KIRKLEES METROPOLITAN COUNCIL INVESTMENT & REGENERATION SERVICE

Reference No:	2024/62/93476/E
Site Address:	7, Hall Drive, Norristhorpe, Liversedge, WF15 7AH
Description:	Erection of single storey front extension and external alterations following removal of existing dormer extension.
Recommending Officer:	Nicole Helliwell

Officer Report

Drawing Number 21-143 - P - 03 - C

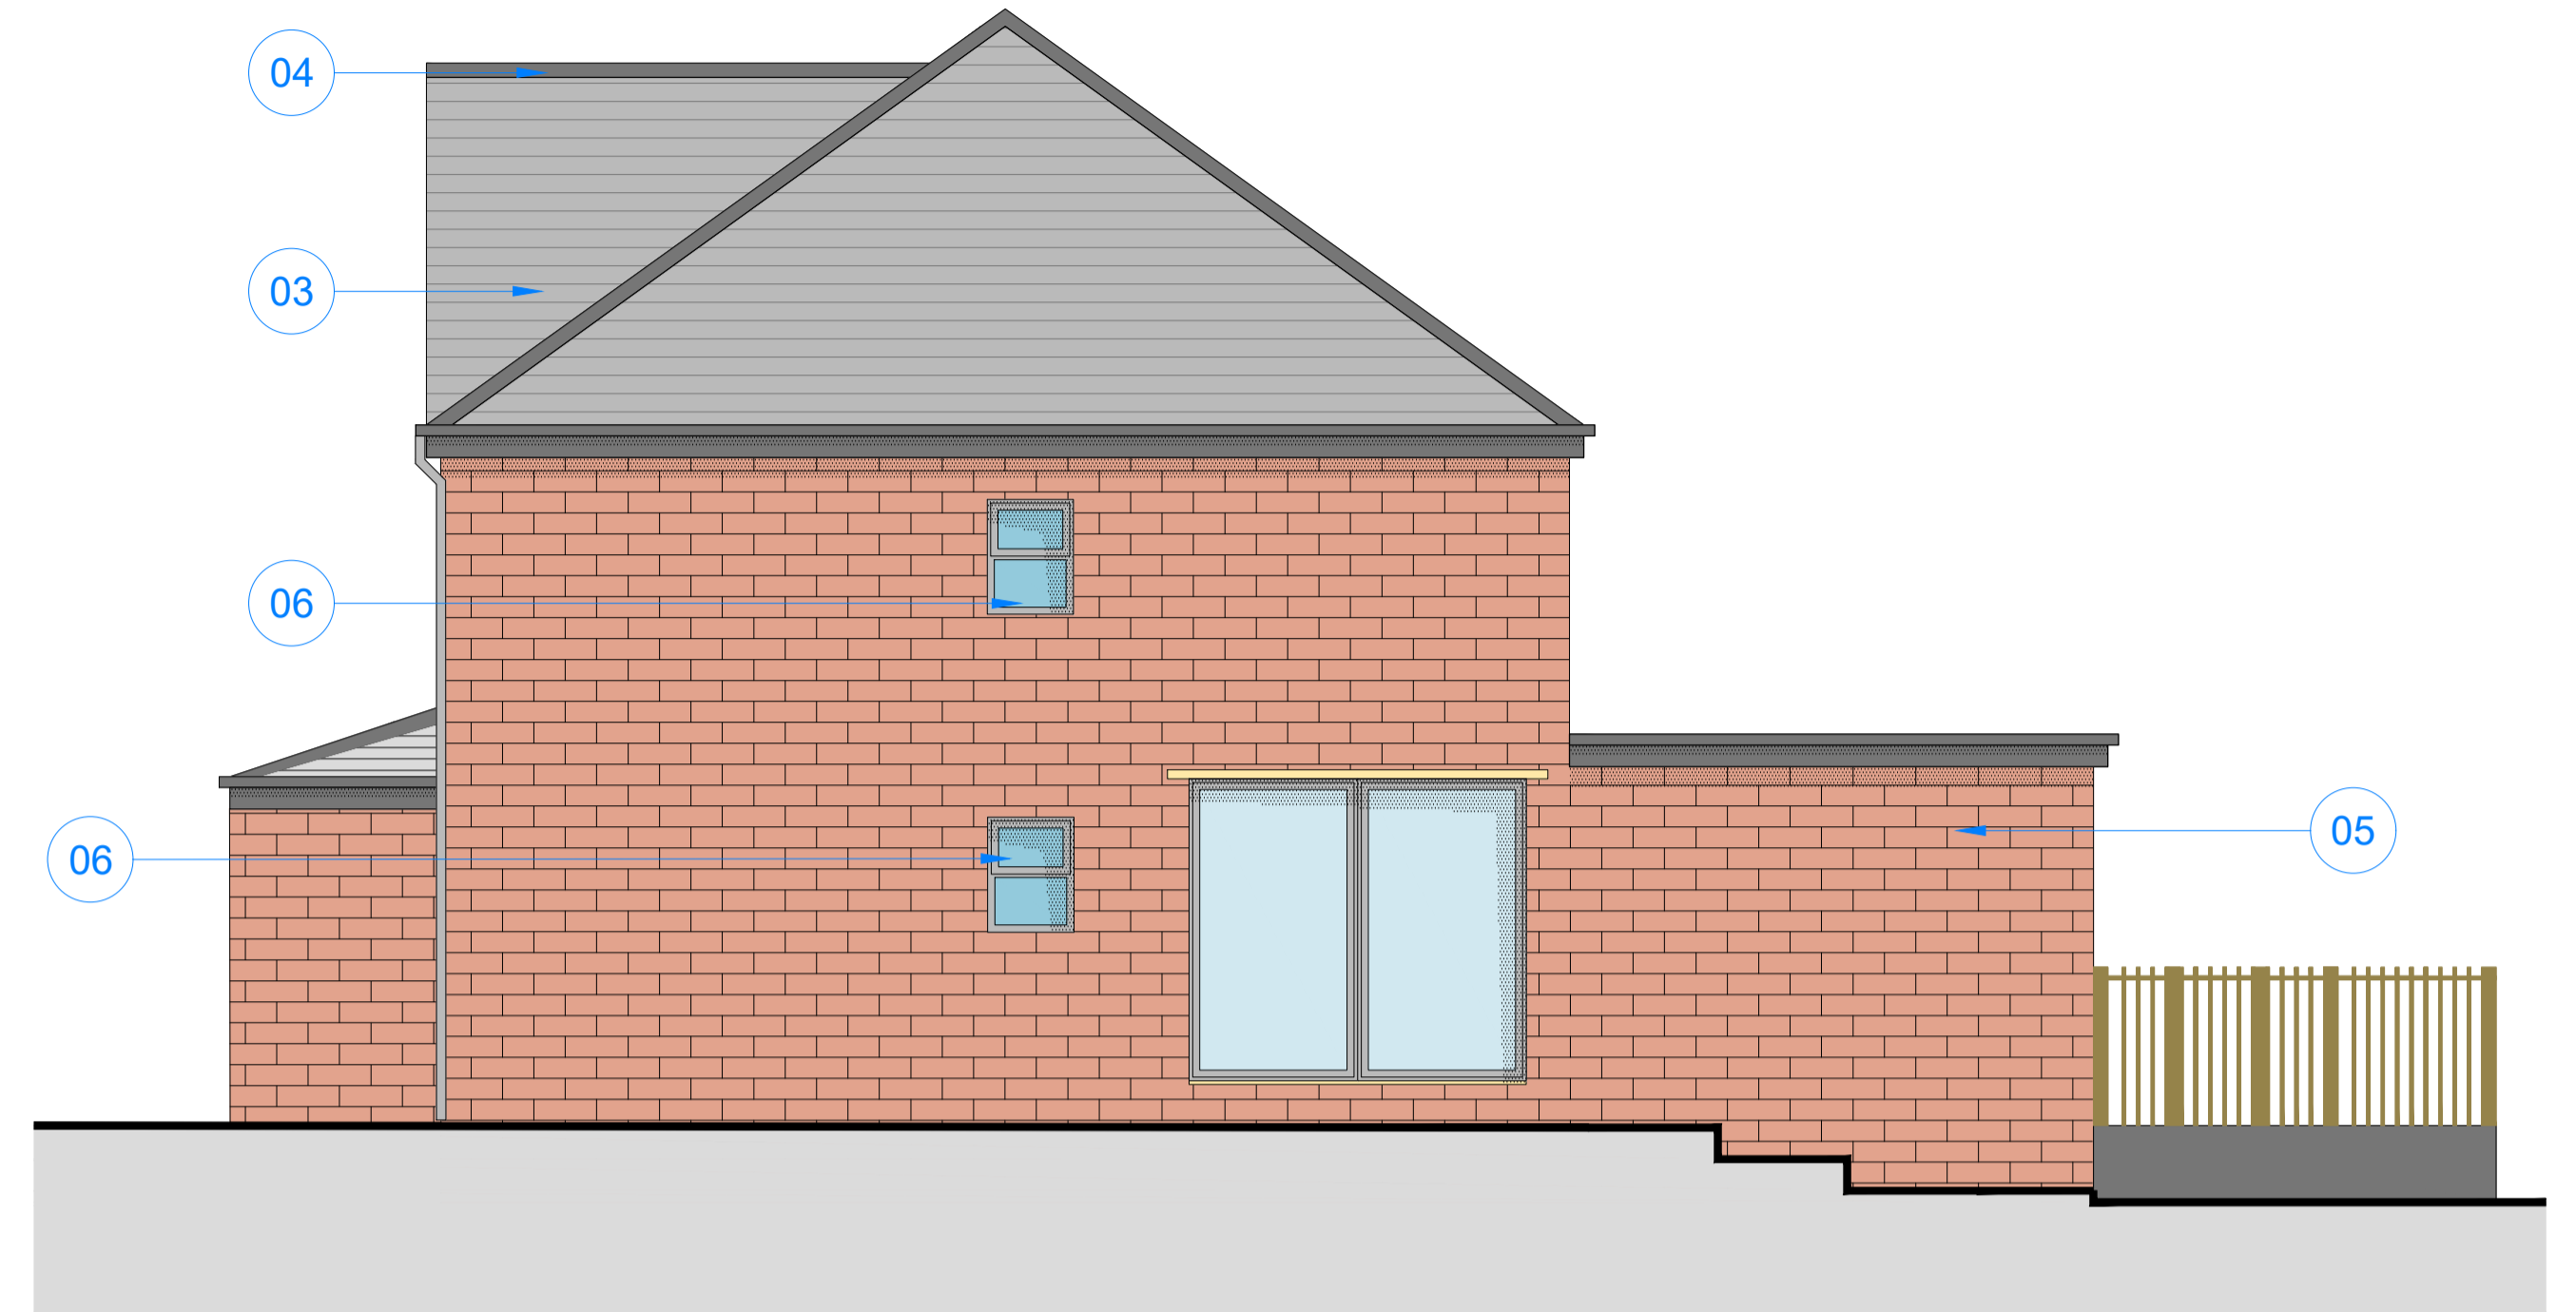
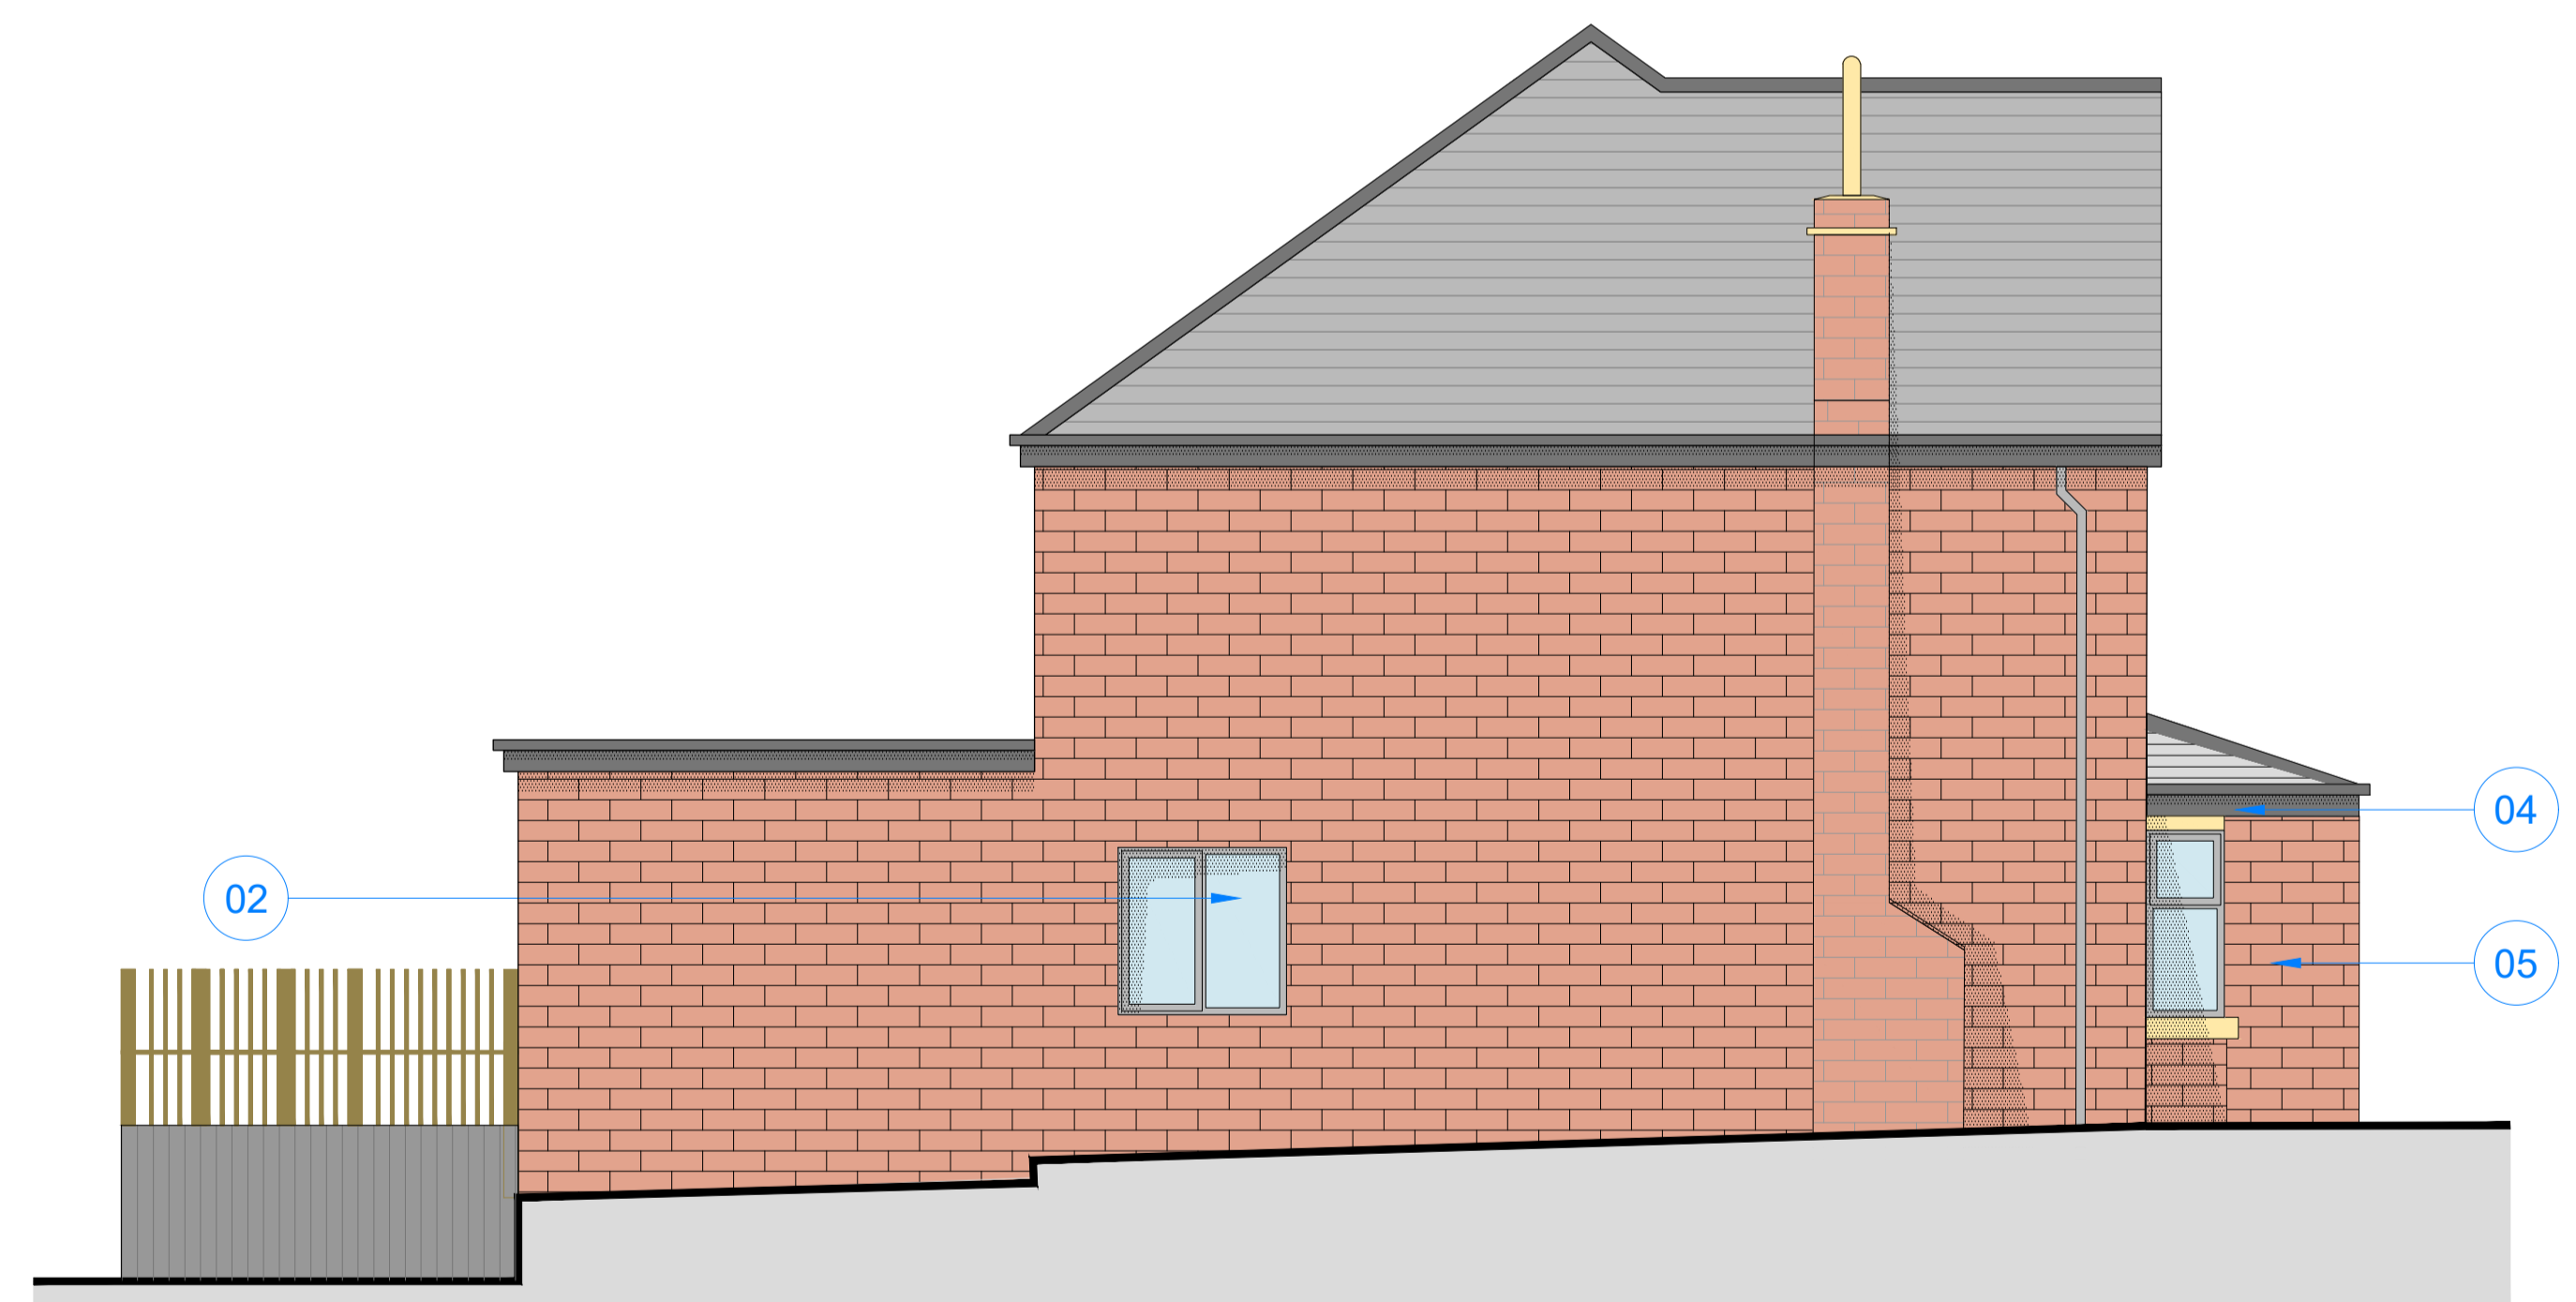
The submitted plans confirm that the existing dual-pitched roof would be converted to a hipped roof form as part of the application. Whilst it is noted that the overall height of the property would increase by approximately 0.97m, it is considered that the alterations would not appear out of character with other properties in the street scene, where there are a variety of roof forms.

The submitted plans confirm that alterations would be made to the existing fenestration within the northern, western and eastern elevations of the dwelling. Furthermore, a new window would be installed within the southern elevation of the property. Given that the fenestration would be appropriately designed and

It is noted that alterations would be made to the existing raised decking as part of the application. The raised decking would measure approx. 1.1m in height and approx. 2.2m cumulatively with the balustrade. Although the raised decking would measure approximately 0.52m higher than the existing, it would be sited to the rear of the dwellinghouse with limited visibility from public vantage points. On this basis, it would be acceptable with regard to visual amenity.

The submitted plans demonstrate that new fenestration would be proposed within the eastern elevation of the dwelling. It is noted that the fenestration would serve an ensuite and a bathroom, which are non-habitable rooms. Should planning permission be granted, a condition would be imposed requiring these windows to be obscurely glazed to protect the amenity of the neighbouring occupants.

The submitted plans confirm that the existing high level window would be removed and a new lounge window would be installed within the western elevation of the dwelling. However, given that the lounge window would be of secondary nature, it is not considered to have a significant impact on the neighbour's residential amenity.

The raised decking would be located approximately 1.2m from the common boundary shared with 5 Hall Drive. Although the decking would measure approx. 0.52m higher than the existing, it is considered that the proposed alterations would not cause any additional overlooking harm to the residential amenity of the neighbouring occupants, over and above the existing arrangements on site.

5. The proposed W.C and ensuite windows in the eastern side elevation of the dwelling shall be fitted with obscure glazing to at least Level 3 on the Pilkington Scale and retained as such thereafter.
